**WEST SUSSEX COUNTY COUNCIL
FLOOD RISK MANAGEMENT CONSULTATION**

PLANNING REFERENCE: LU/376/17/OUT

LOCATION: The Bungalow, Southdown Nursery, Old Mead Road, Littlehampton, West Sussex, BN17 7PU

TYPICAL RAIN GARDEN
ILLUSTRATIVE DETAIL
(NTS)

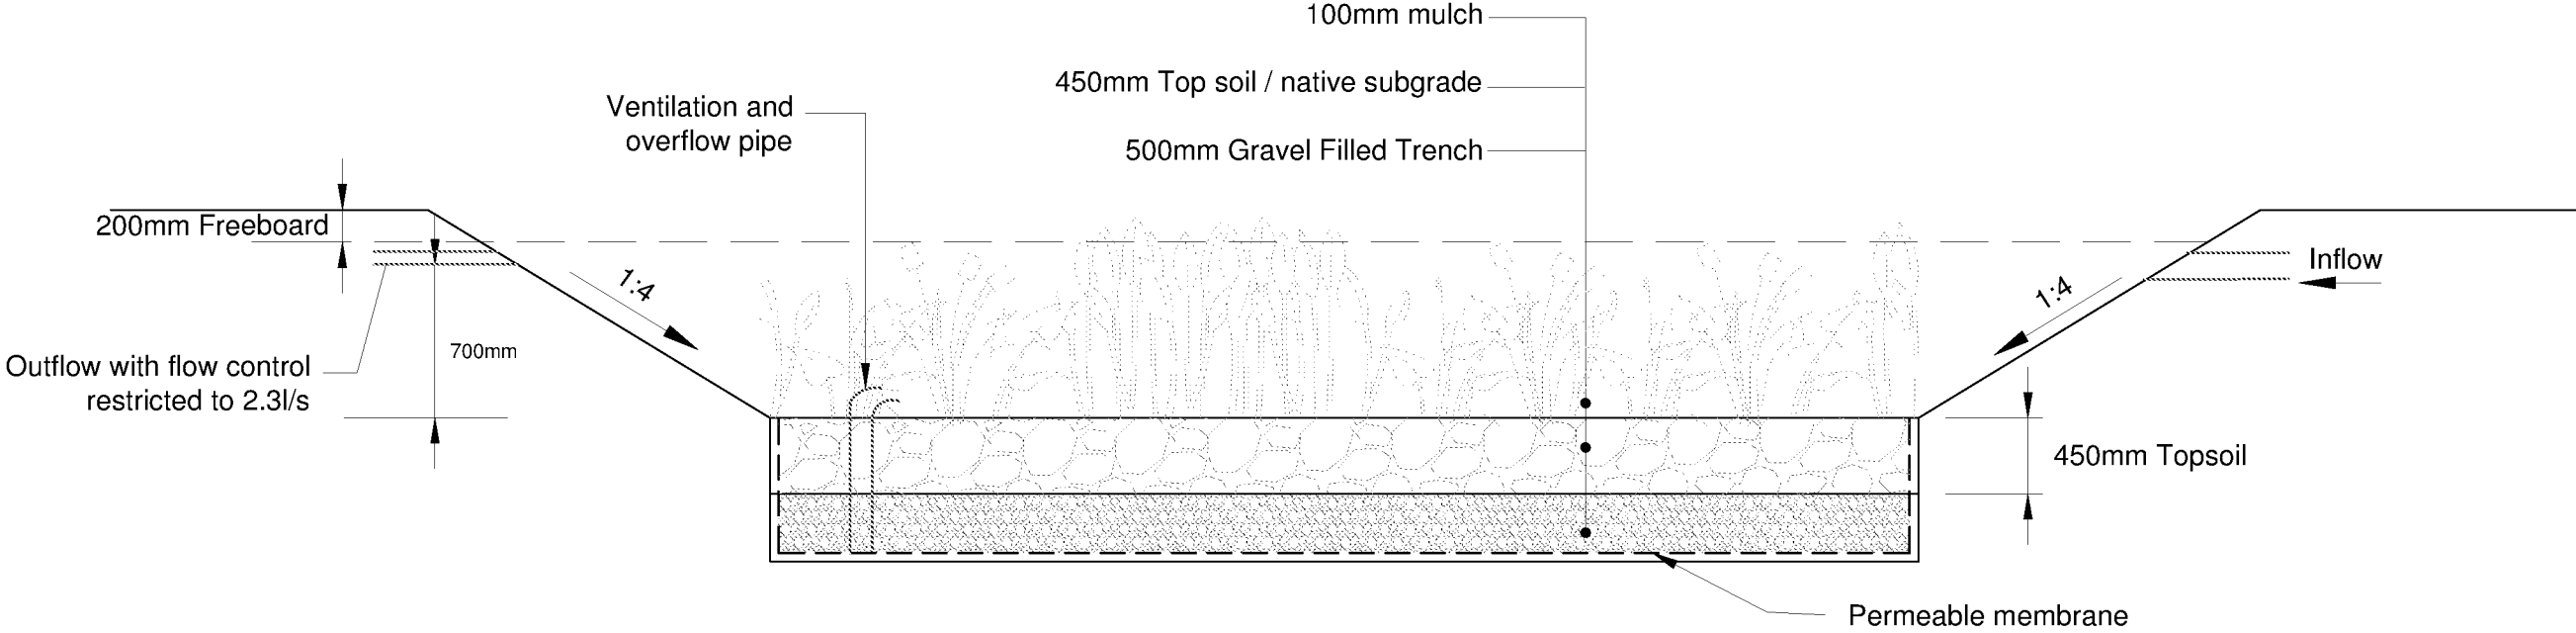
The FRA for this application proposes that Sustainable Drainage techniques (swales, detention basin, rain garden, French drains) would be used to control the surface water run-off from this development to Greenfield rates. The Preliminary Drainage Strategy Layout in Appendix 10 only shows a rain garden/basin as part of the design.
